From: Laura Gibbons
Sent: 05 September 2019 10:00
To: Planning.Responses <Planning.Responses@arun.gov.uk>
Subject: RE: Planning Consultation on: AB/88/19/PL

Engineers Comments Regarding Surface Water Drainage

APPLICATION NO: AB/88/19/PL

Description of Works: 38 No residential apartments (9 No 1-bed units & 29 No. 2-bed units) along with access, off-street parking, amenity space & enhancements to the local footpath network.

DRAINAGE LAYOUT DRAWINGS

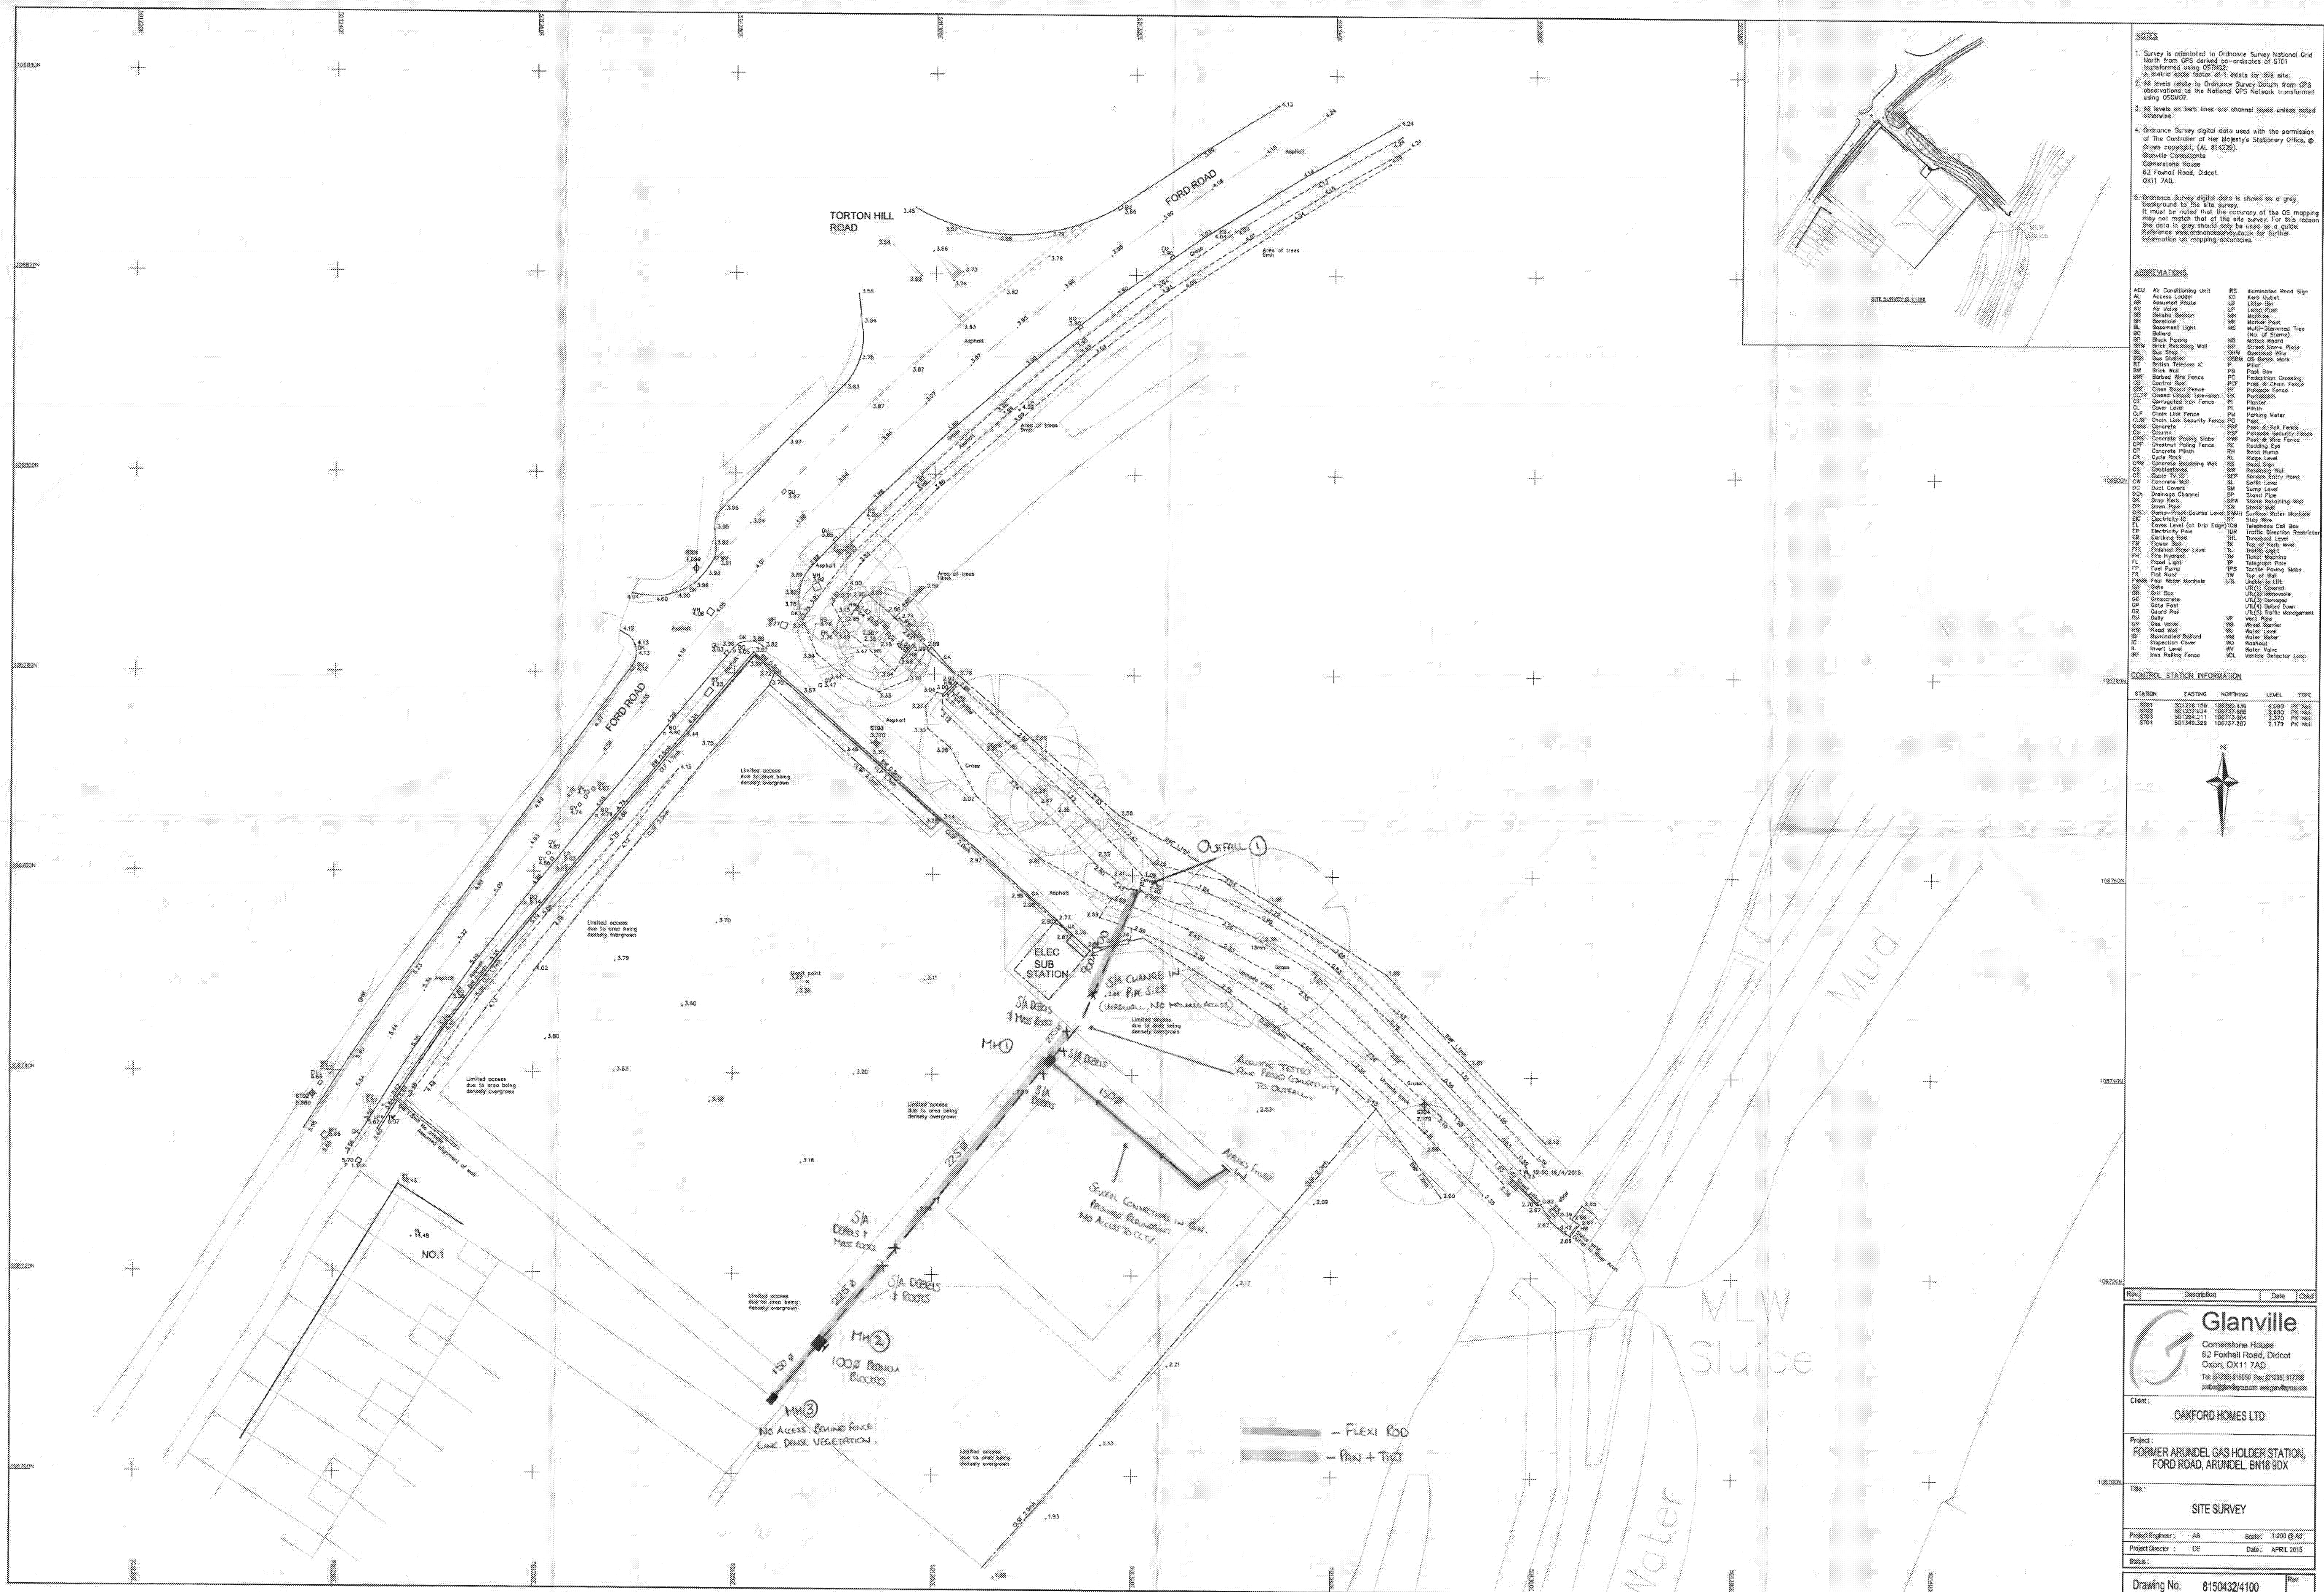
The existing culverted watercourse must not be removed unless it is conclusively proven that this is no longer in use.

Table 3 Flood plain compensatory storage (Flood Level to Finished Ground Level)

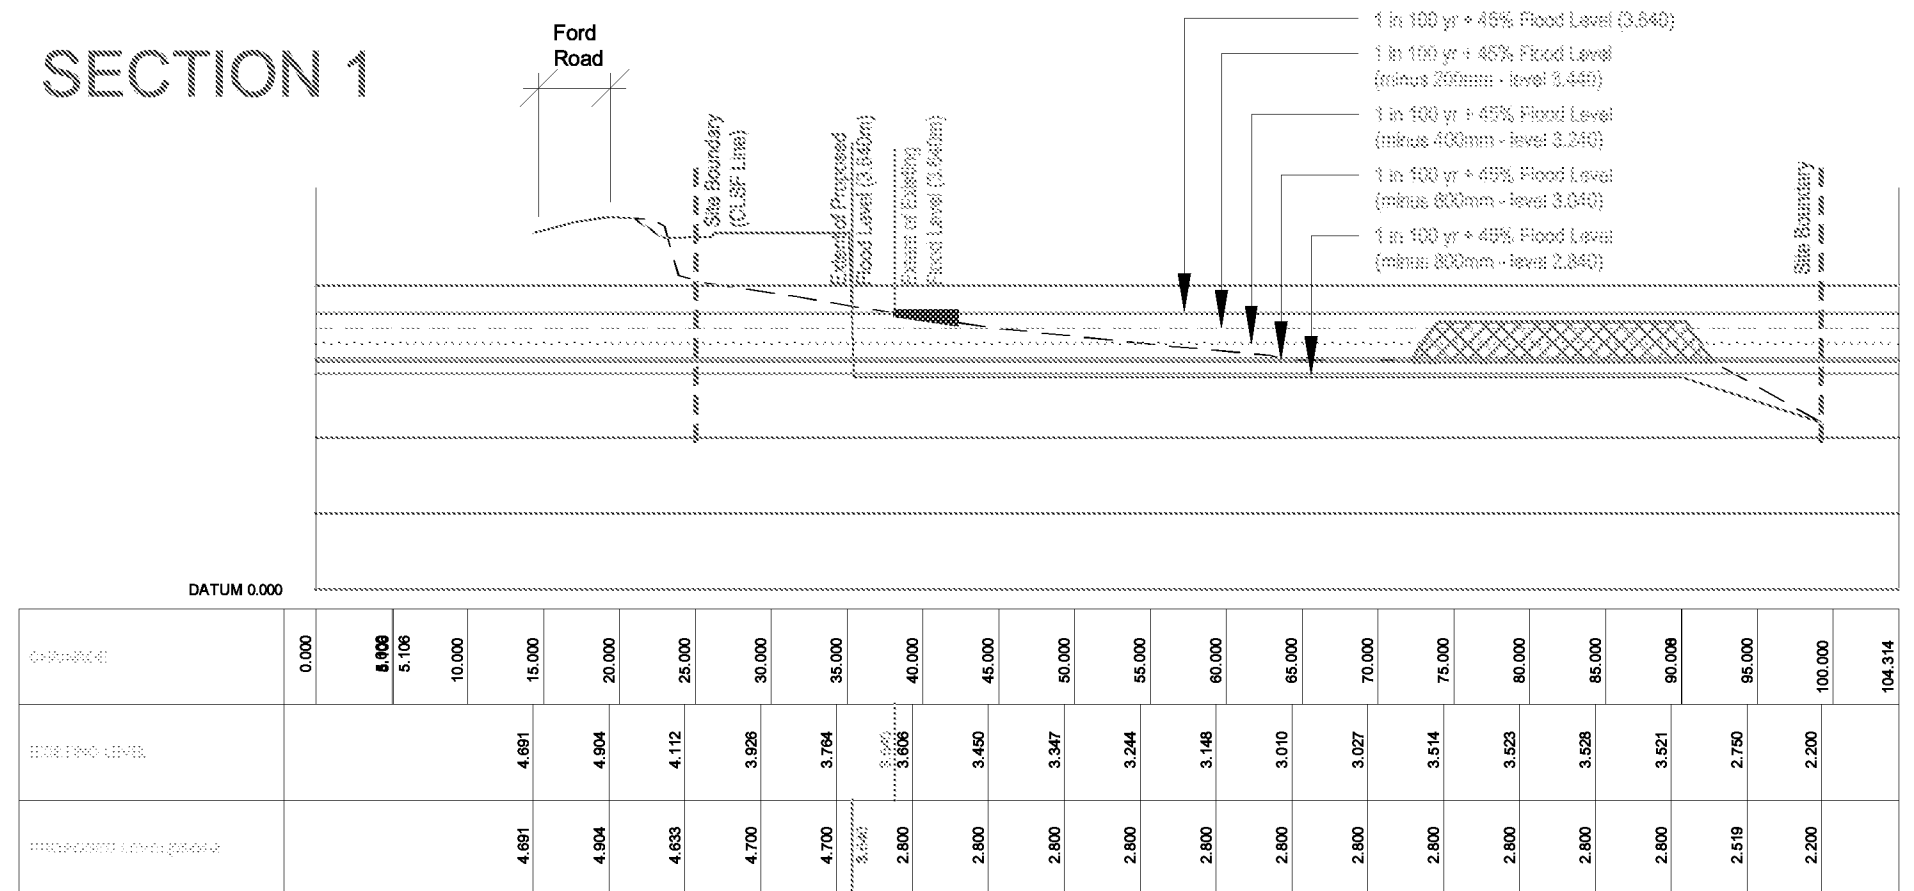
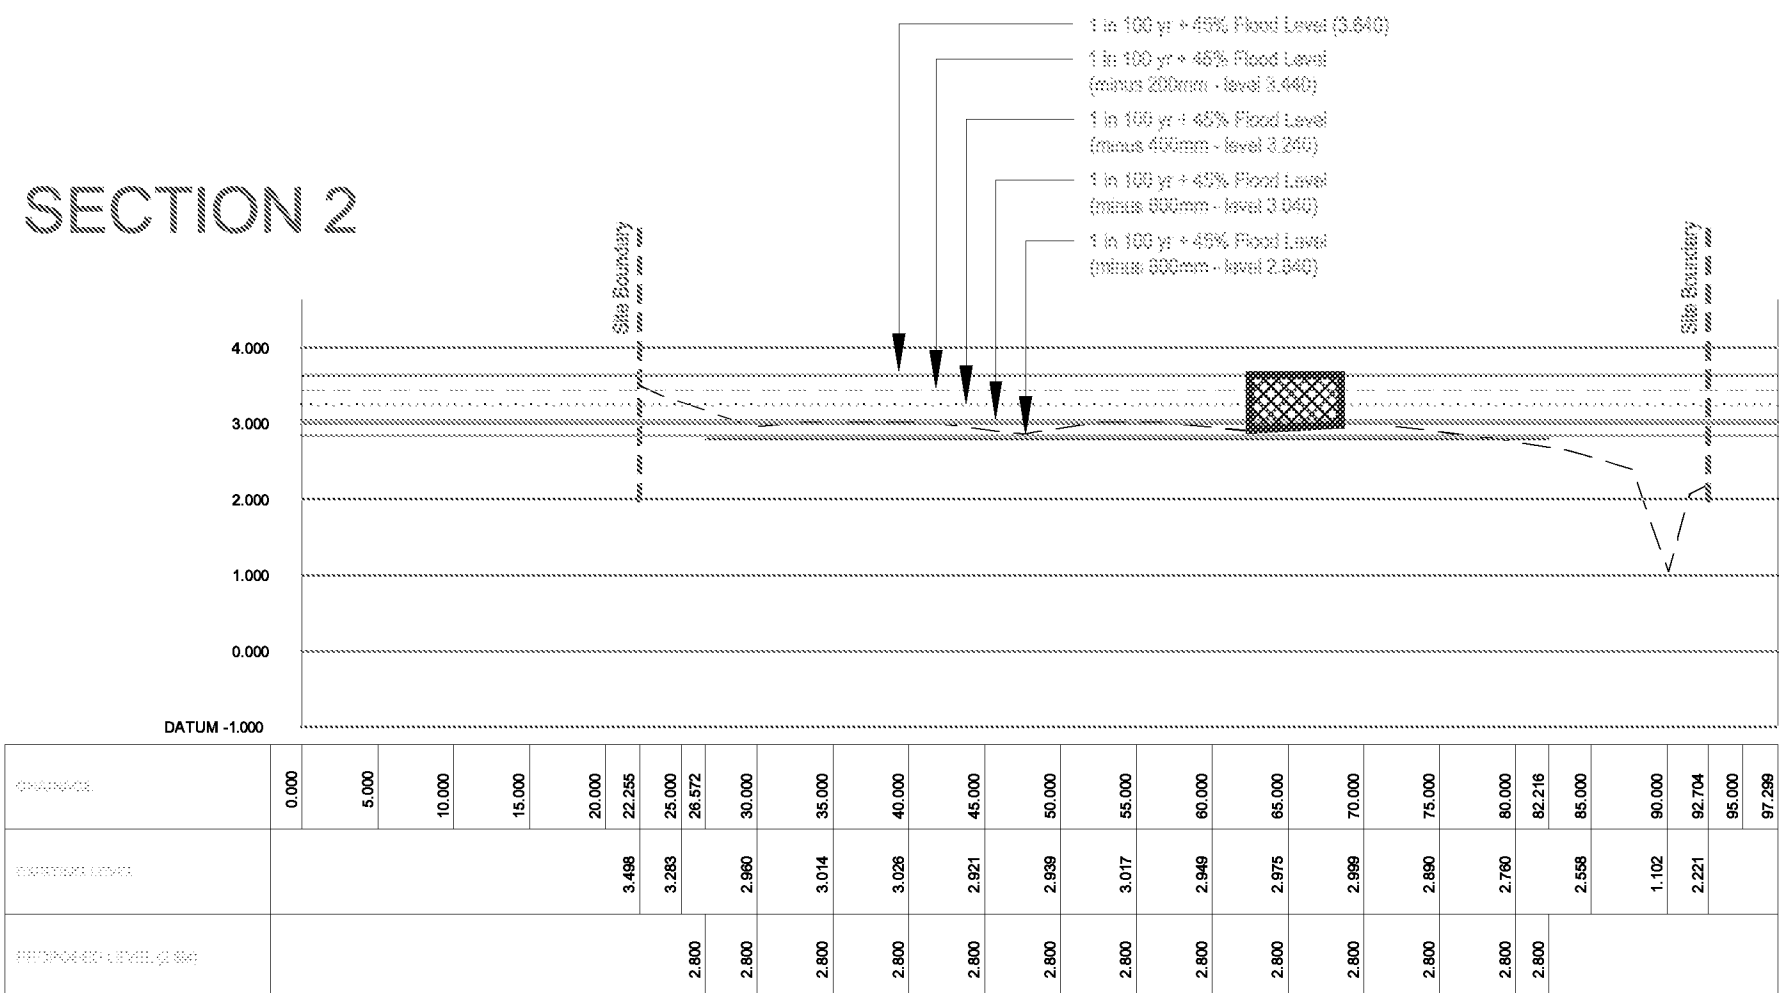
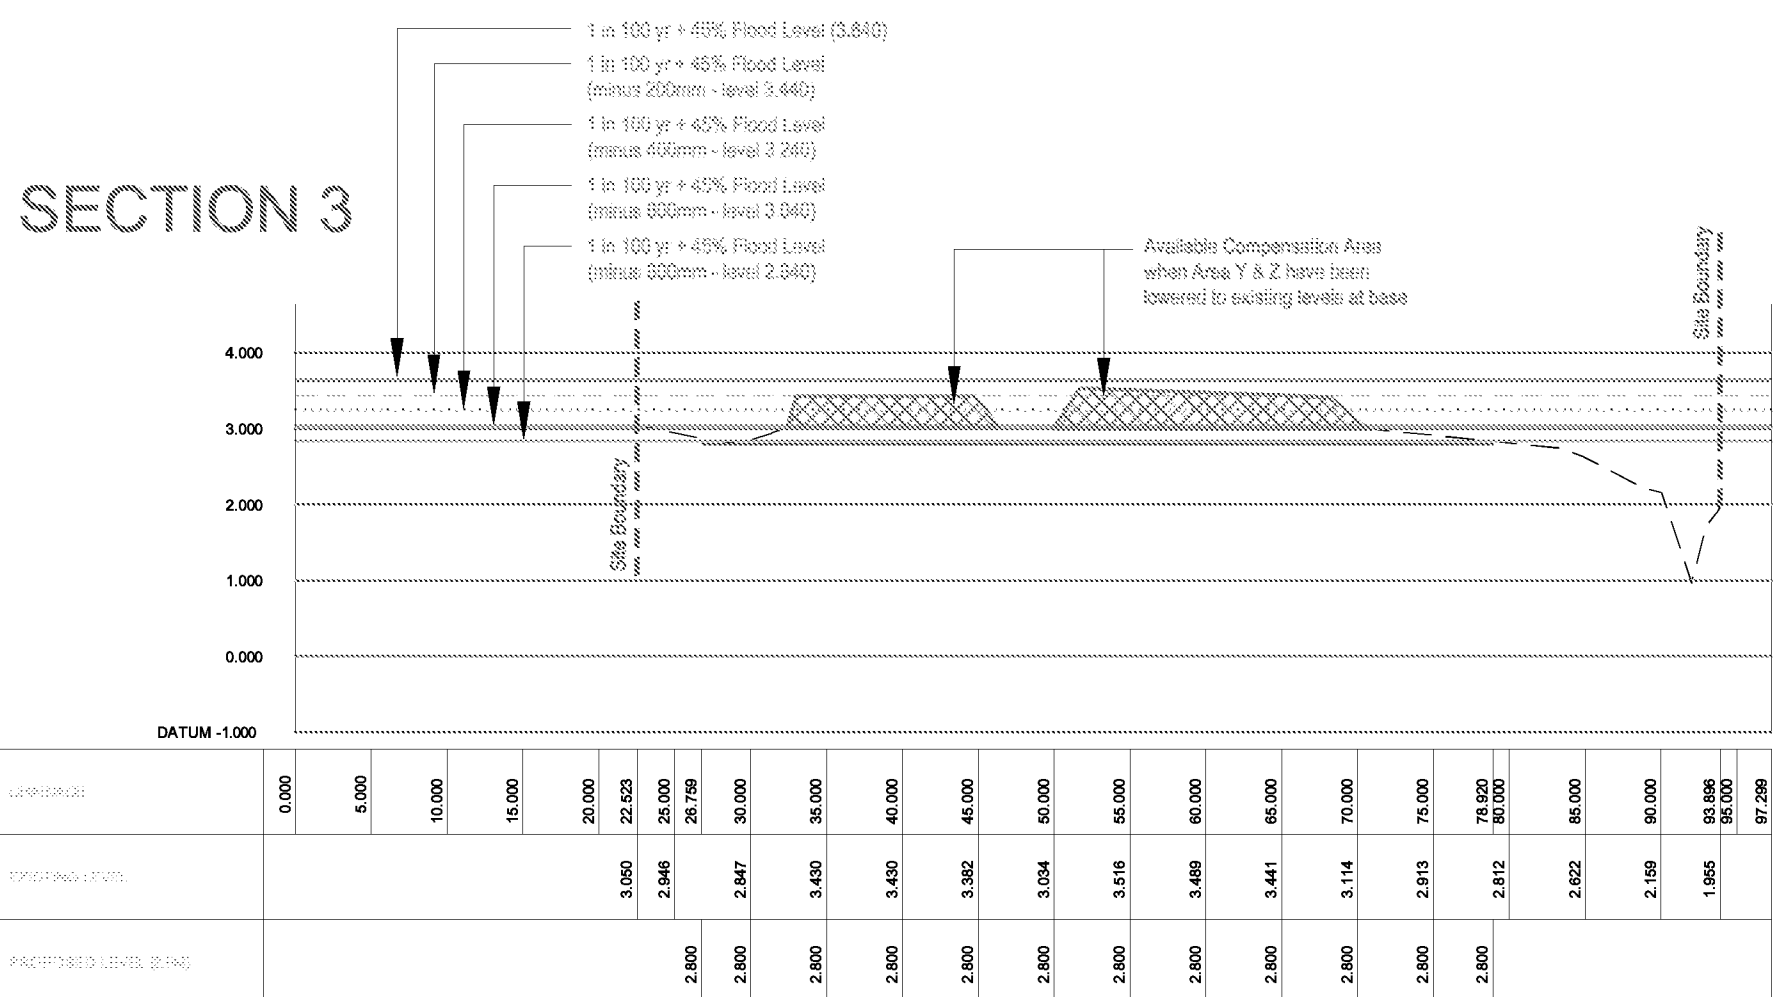
No attenuation of surface water should occur within the flood plain, it is unclear how this can possibly be achieved, and therefore there is a significant risk that flood risk will be increased elsewhere.
